## WEDDIN SHIRE COUNCIL

6 June 2022

**RE: SSD – 13855453 – Grenfell Poultry Breeder Farm  
Lot 1 DP 1022013, Lots 1-3 DP 1206485 and Lot 22 DP 866857**

DRAWING TITLE	EXIT TO GOOLOOGONG SWEEP PATH
CLIENT	BAIADA
PROJECT	GRENFELL FARMS
LOCATION	1130 GOOLOOGONG ROAD, GRENFELL, NSW

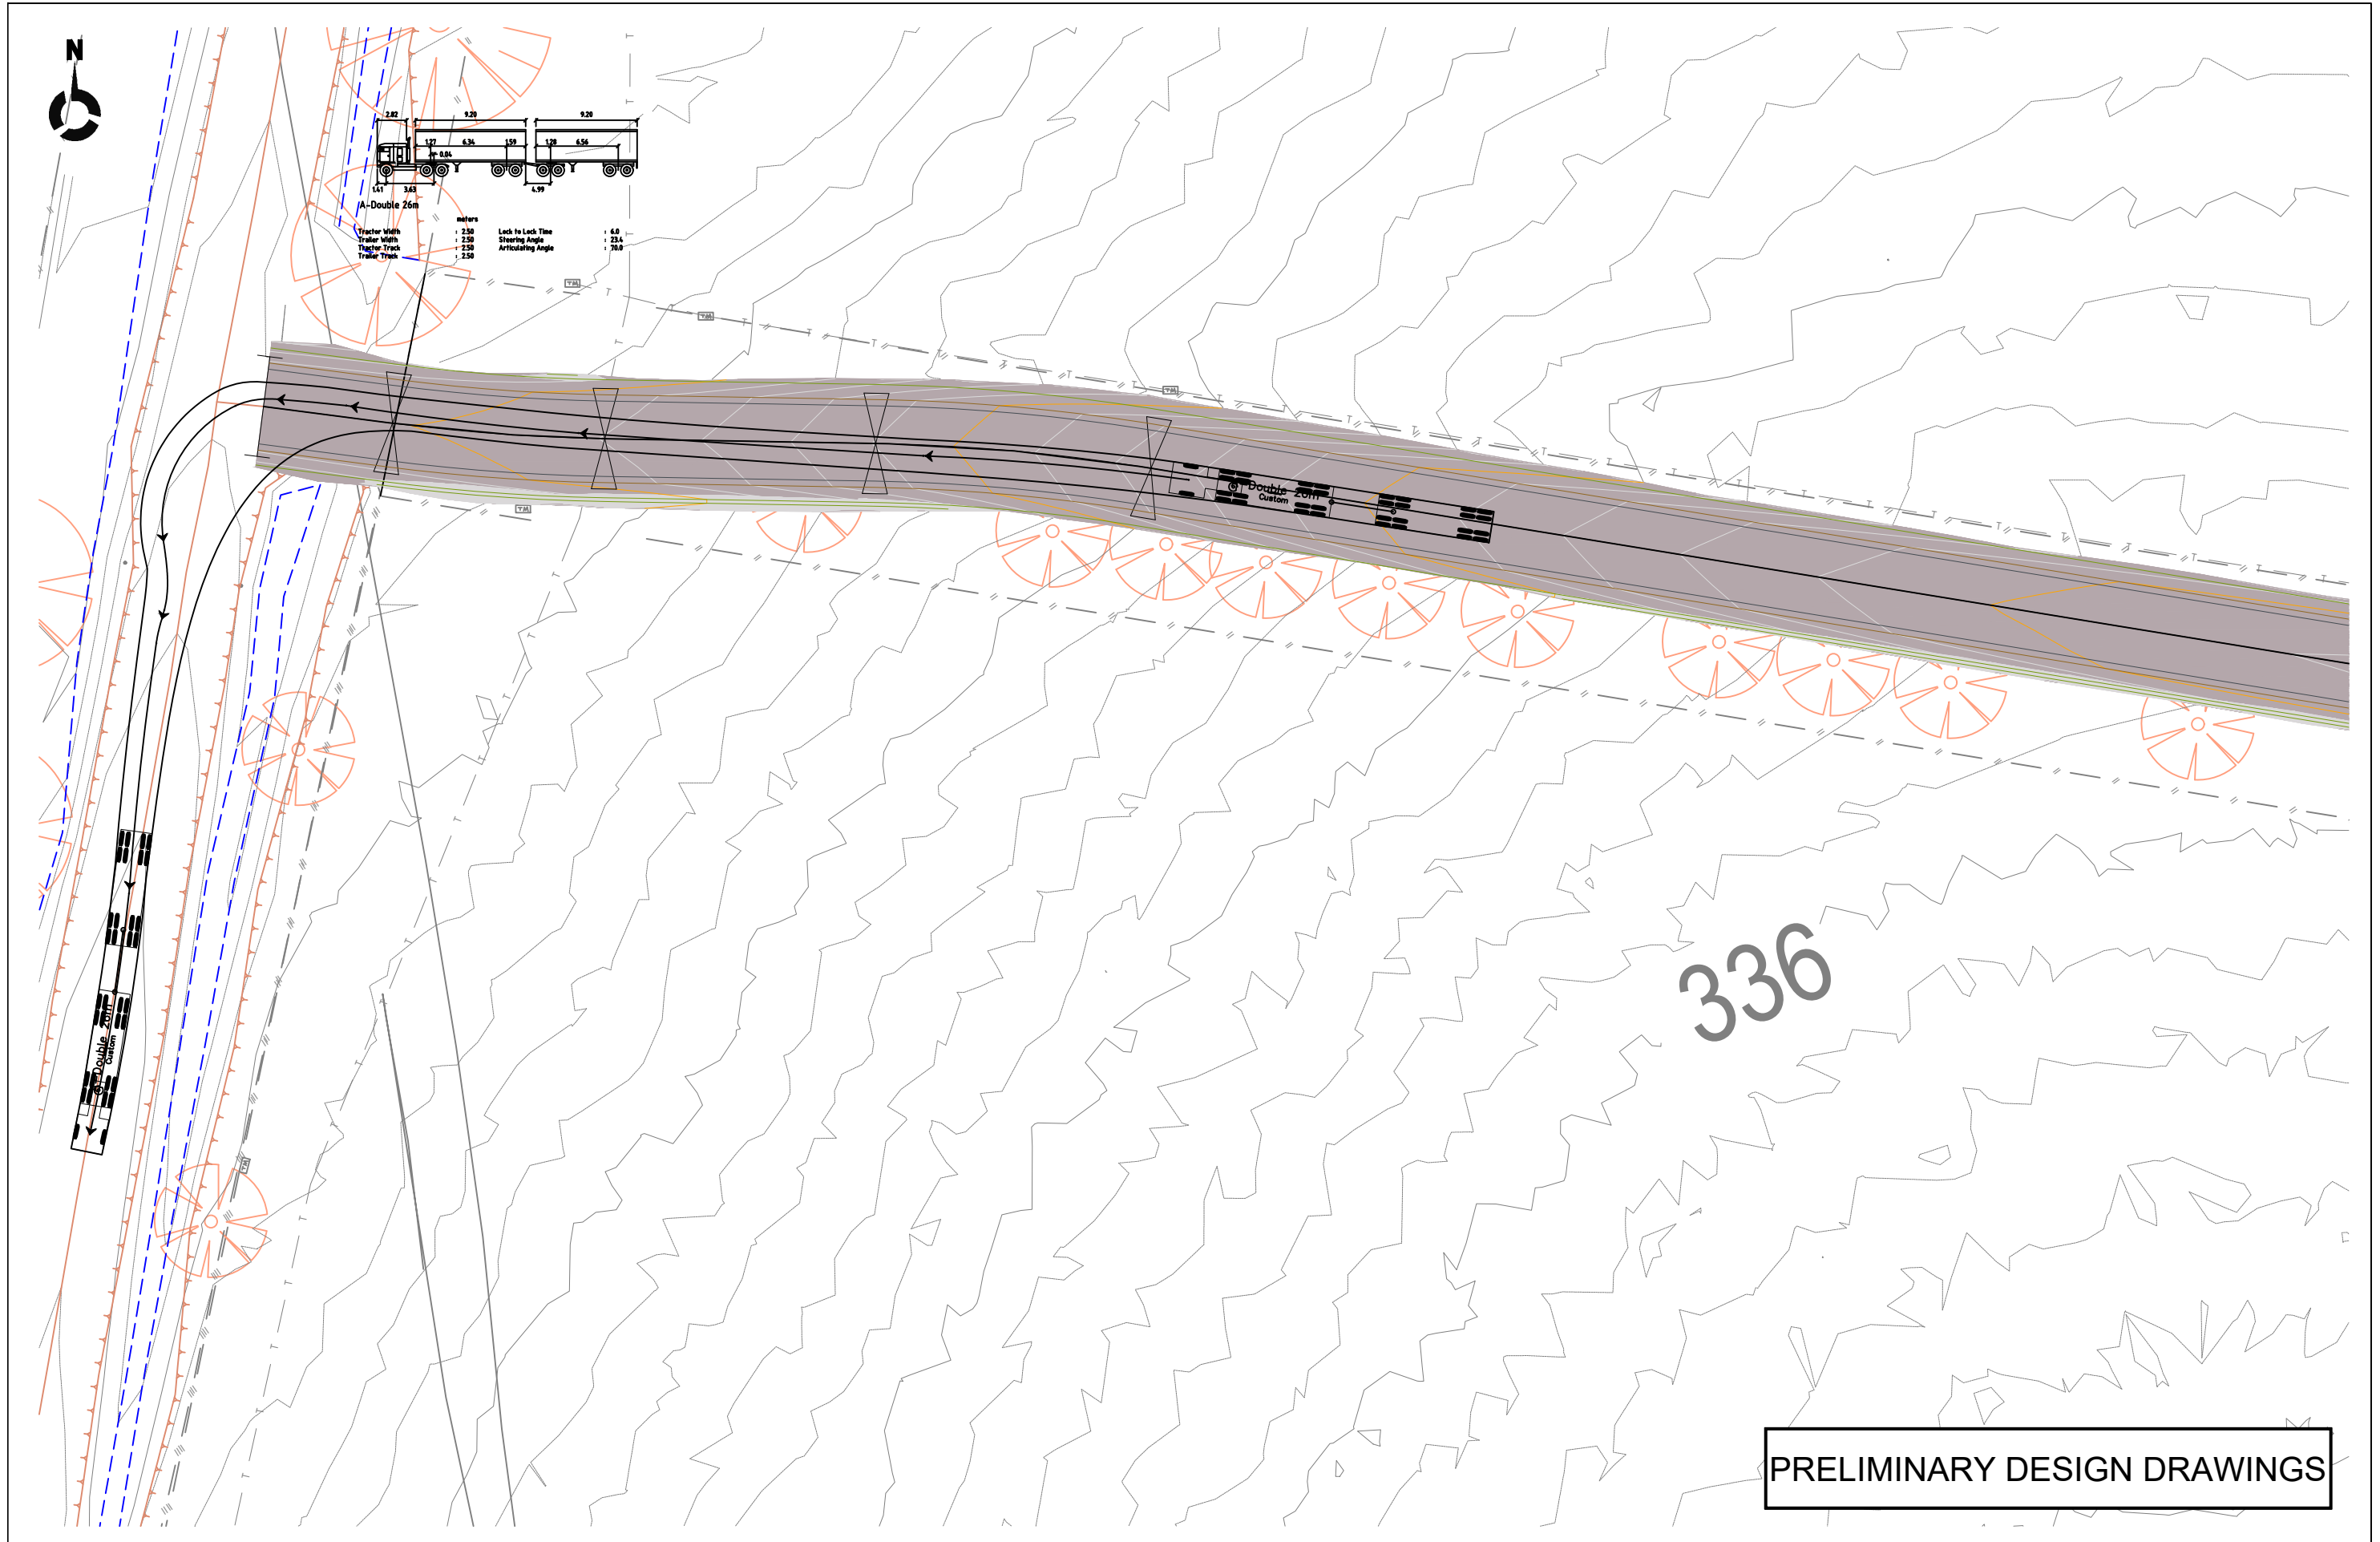
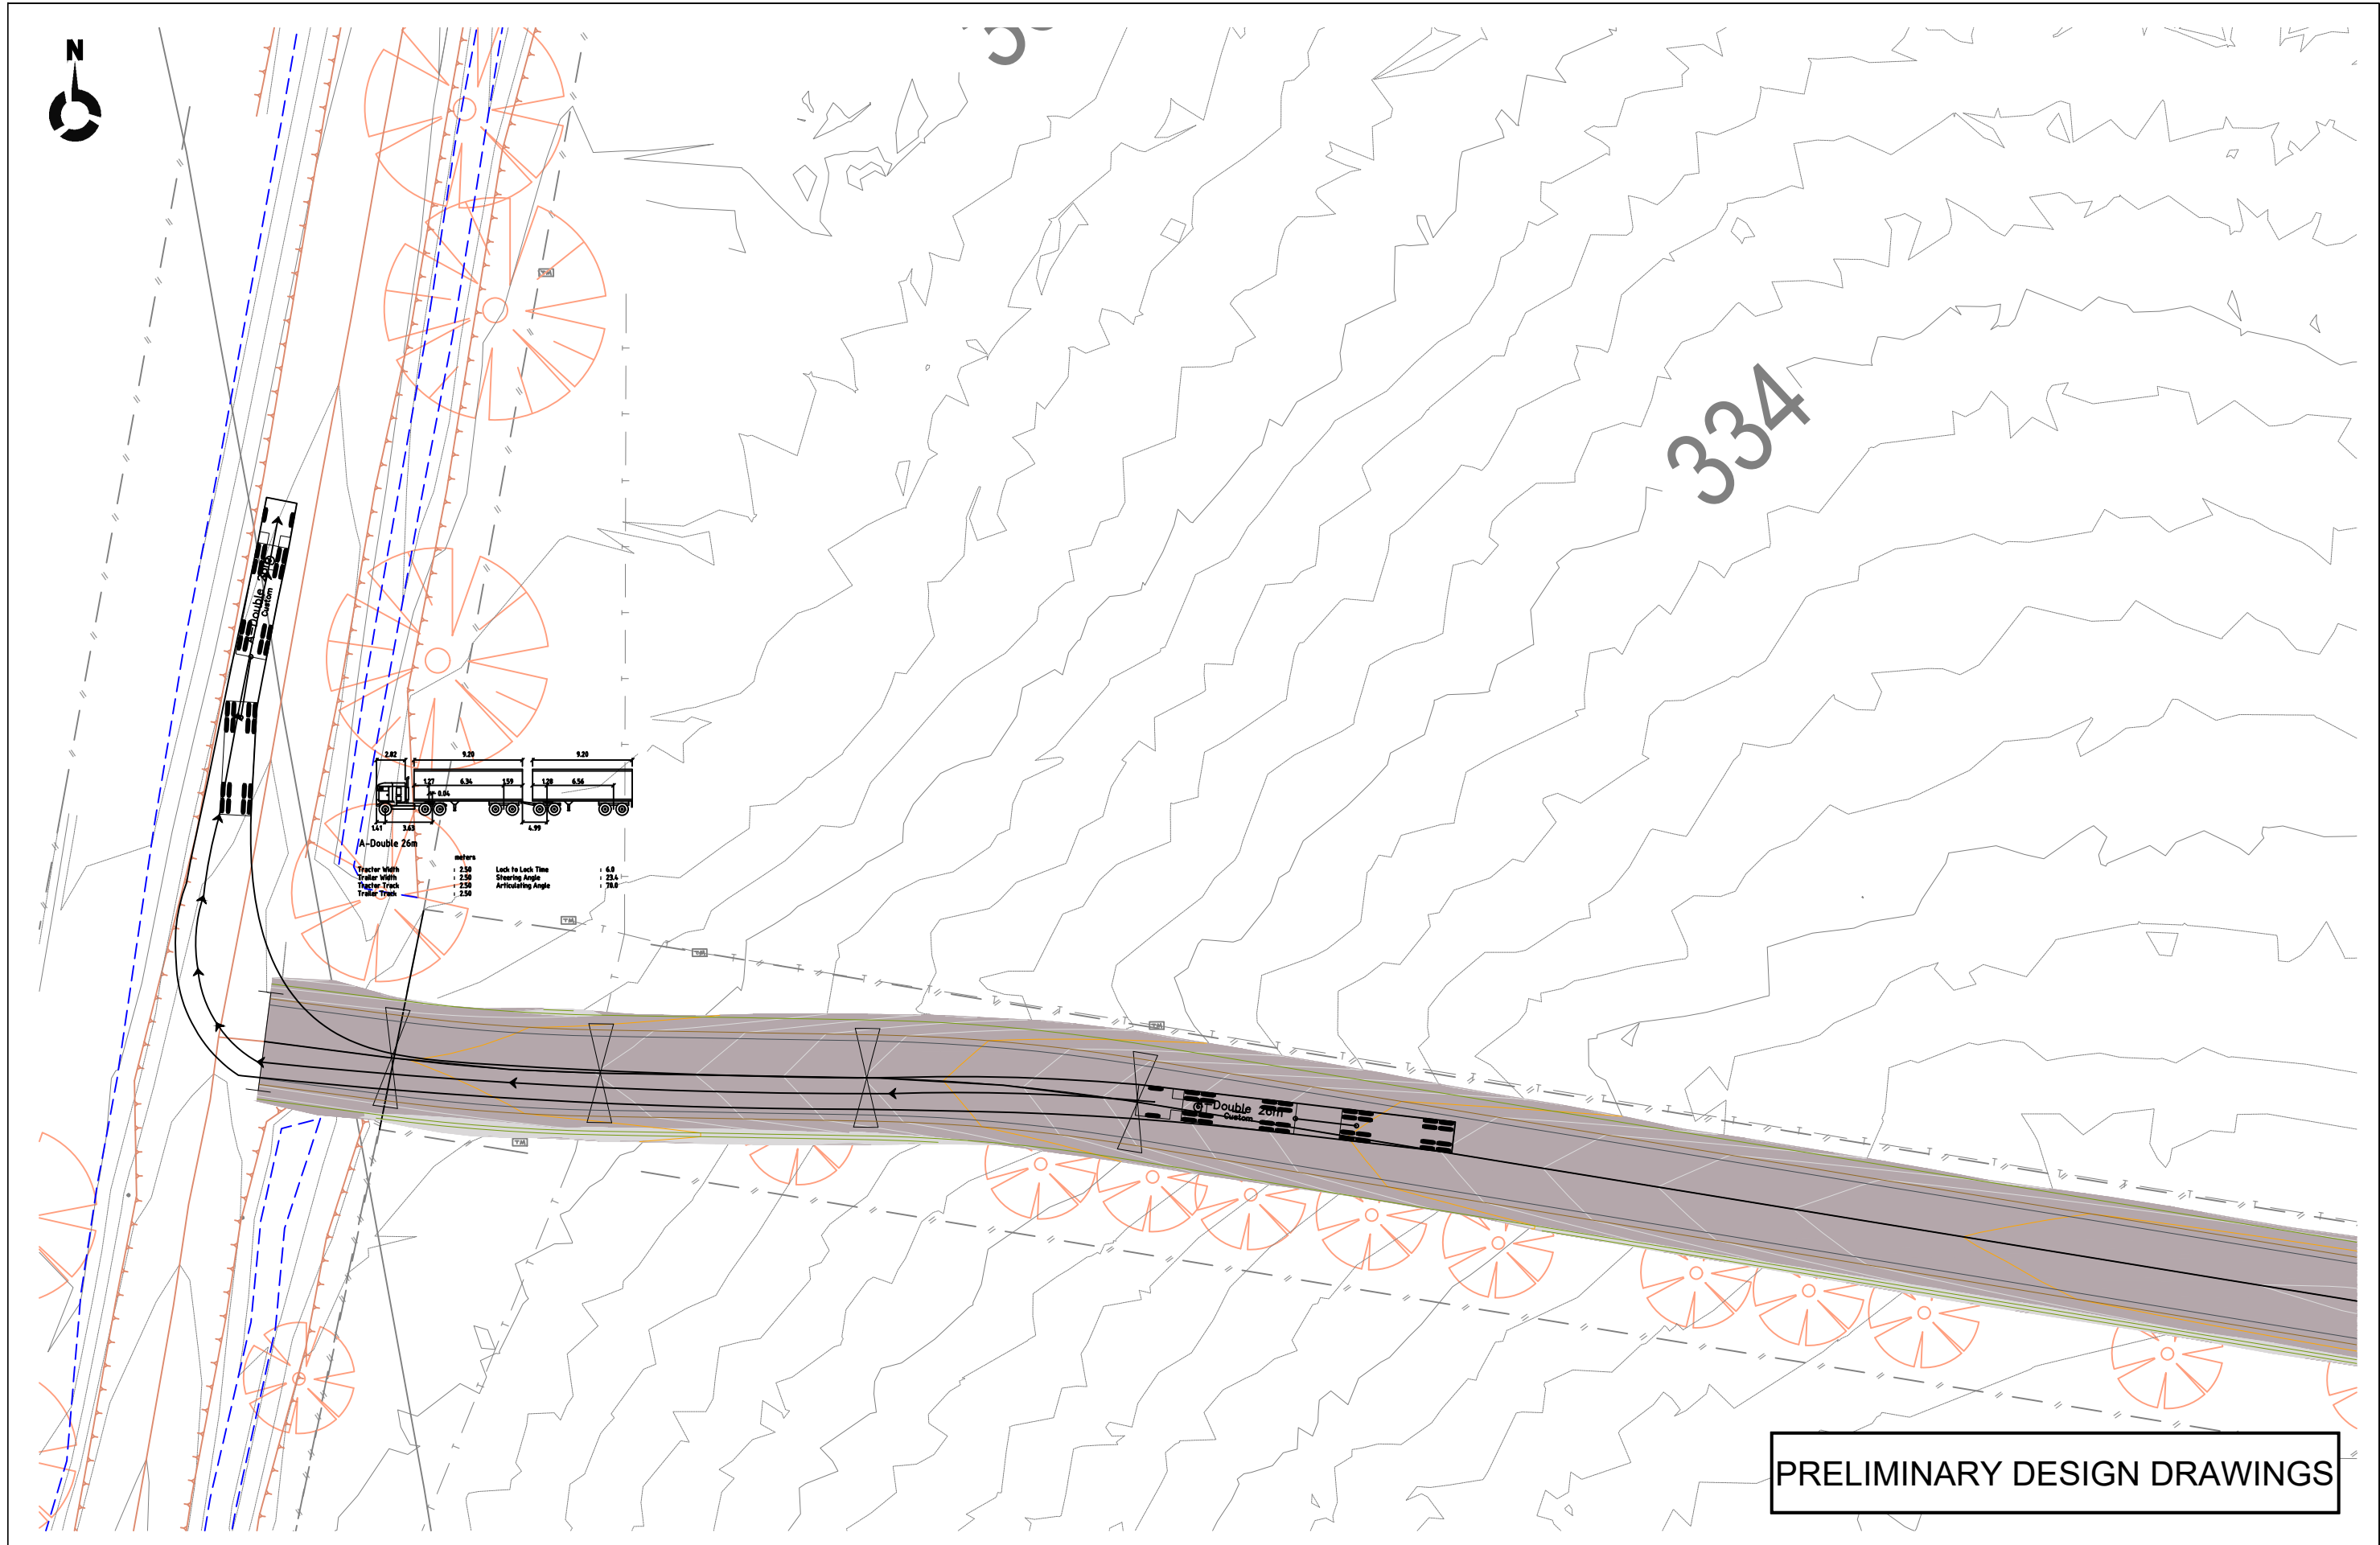
- Council is of the opinion that the proposed entry/exit is required to be modified in order to comply with Ausroads Standard to ensure that vehicles are not required to cross onto the opposite traffic lane to enter or exit the property.
